# PLAT V\_1 redlines.pdf Markup Summary [PrimarySort] 10-10-2019

SF 19-015

**PROPOSED PRIVATE 30" RCP STORM MAIN K (OFF-SITE SYSTEM BYPASS)**

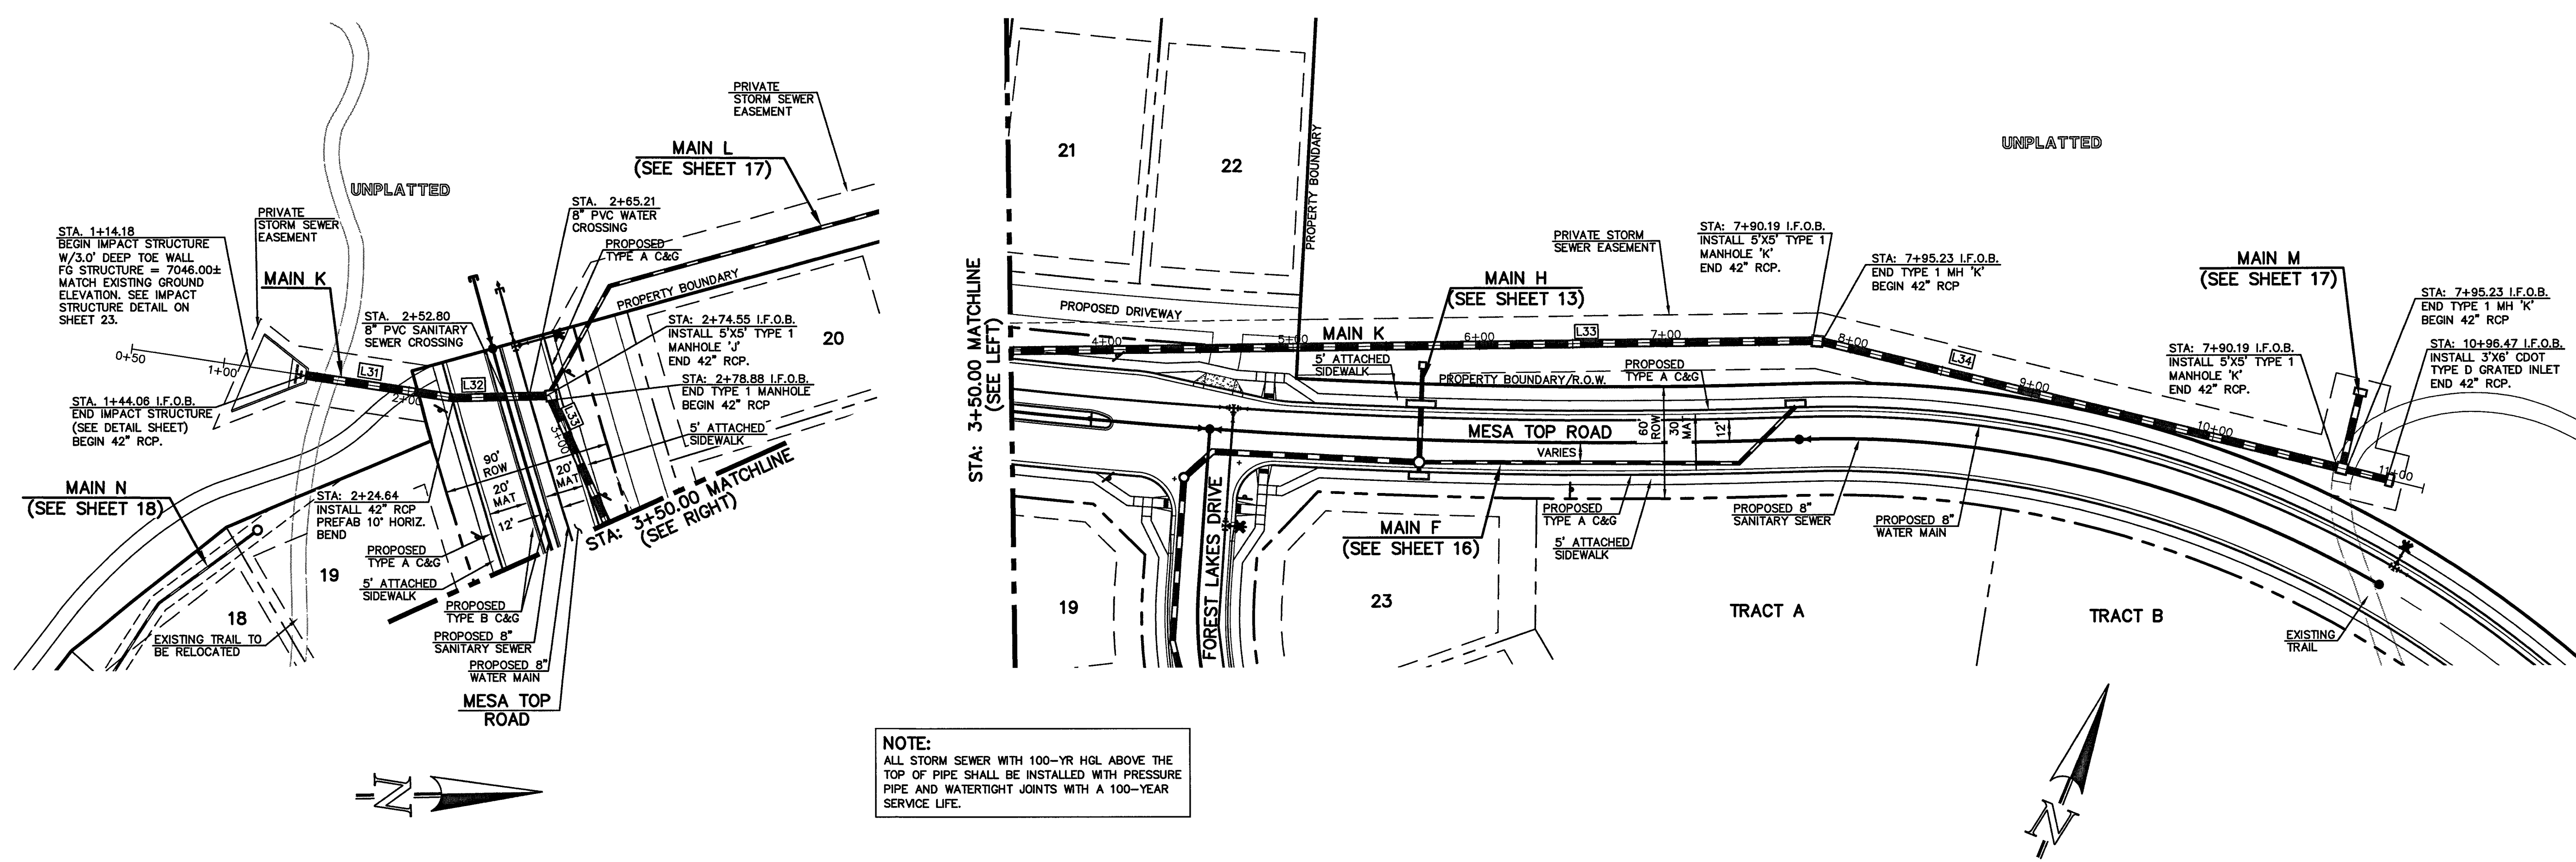
Drainage Easement needed for Storm Main K located within the 30' shared access.

REVISED
